Please ask for: Ms Iqraa Malik
Email: iqraa.malik@terraquest.co.uk
Telephone: 01212341390
Our Ref: WA/39/20/HH
Your Ref:
Date: 26th June 2020

Application for Planning Permission for Works or Extension to a Dwelling

Development: Demolish existing garage and large shed on adjoining properties and replace with semi-detached/linked car ports and garage along joint frontage.
Location: Pilgrim Cottage And Murroes Dairy Lane Walberton BN18 0PT

LOCATION PLAN 1:1250

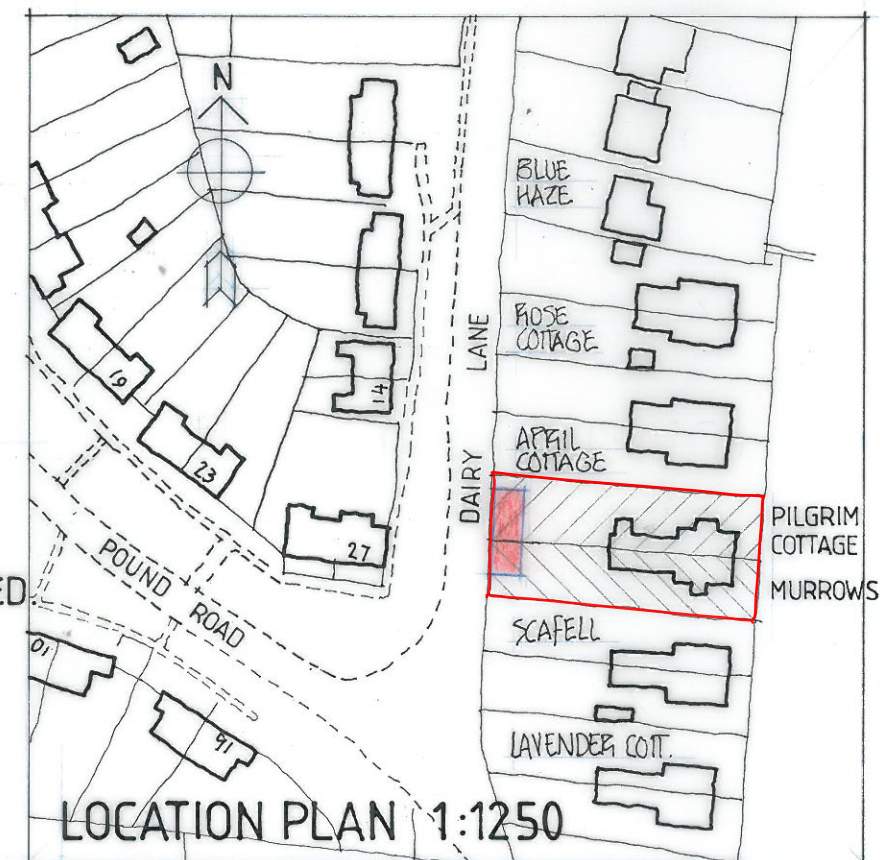
Location Plan: The location plan is required to have a red outline around both sites including the houses. Please amend.

DAIRY LANE
GROUND LEVEL PLYNTH PLAN.

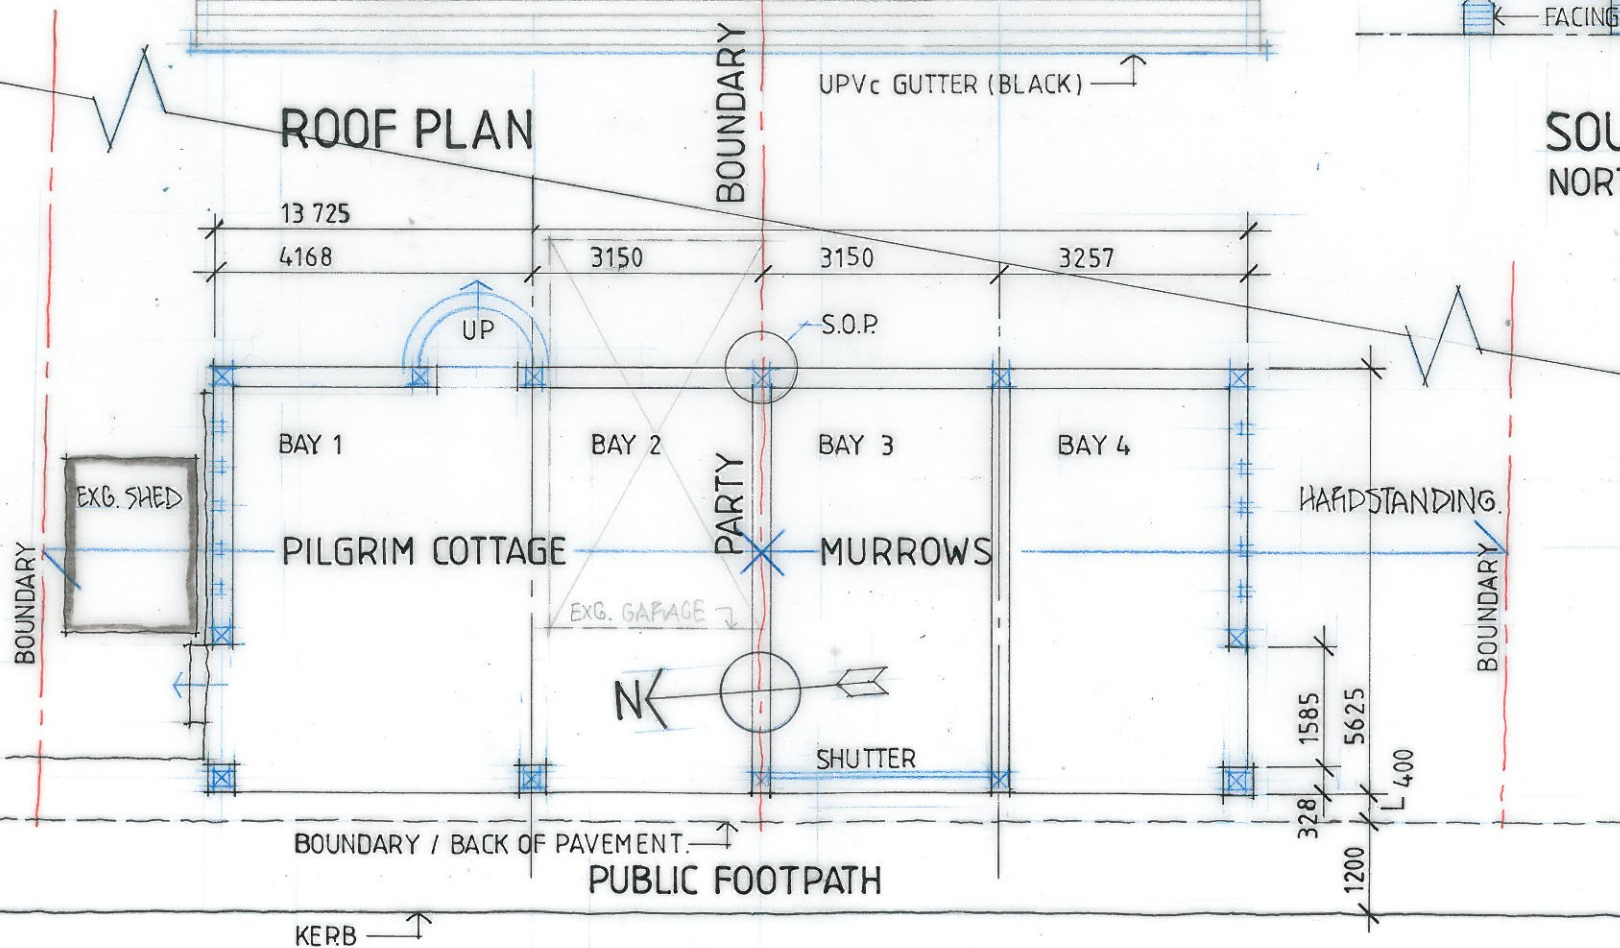
Block Plan: Please submit a proposed block plan and include dimensions from the proposed garage/shed to all site boundaries including a dimension from the garage to the houses.
